11 December 2017

Roads and Maritime Reference: SYD17/00774/02 (A20254471)
DP&E reference: SSD 8529

EXHIBITION OF EIS – BUILDING C1, BARANGAROO SOUTH (SSD 8529)

Figure 9 Approved intersection layout – Hickson Road / Napoleon Street

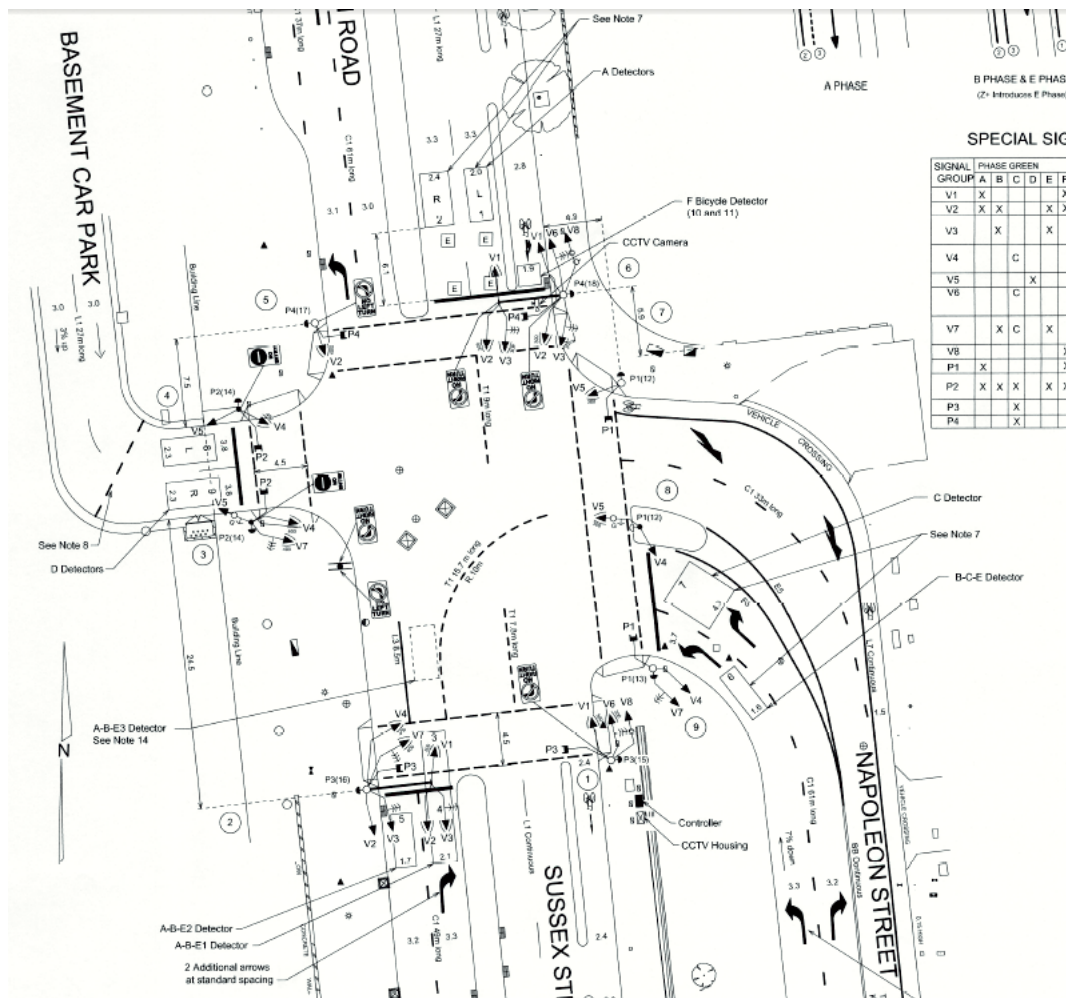
5. Roads and Maritime notes that modifications to the pedestrian crossing width at the signalised intersection of Hickson Road/Sussex Street/Napoleon Street is no longer proposed as part of the subject development.
6. It is noted that the proposal to install traffic control signals at the intersection of Hickson Road/Watermans Quay is mentioned in the Transport Assessment, although it is stated that this would be subject to a separate application.

It should be noted that any proposed installation of a traffic control light, or modification works to an existing traffic control light, requires Roads and Maritime's prior approval in accordance with Section 87 of the *Roads Act 1993*. The installation of a traffic control light is dependent on general warrants in accordance with Roads and Maritime's Traffic Signal Design guide (Section 2 Warrants). It is emphasised that the warrants are a guide only and meeting the warrants does not necessarily mean that this treatment is the best solution. All traffic data would need to be analysed and alternative treatments considered to determine the optimum solution, with consideration to safety and efficiency impacts (particularly given the close proximity to the existing signalised intersection of Hickson Road/Napoleon Street).
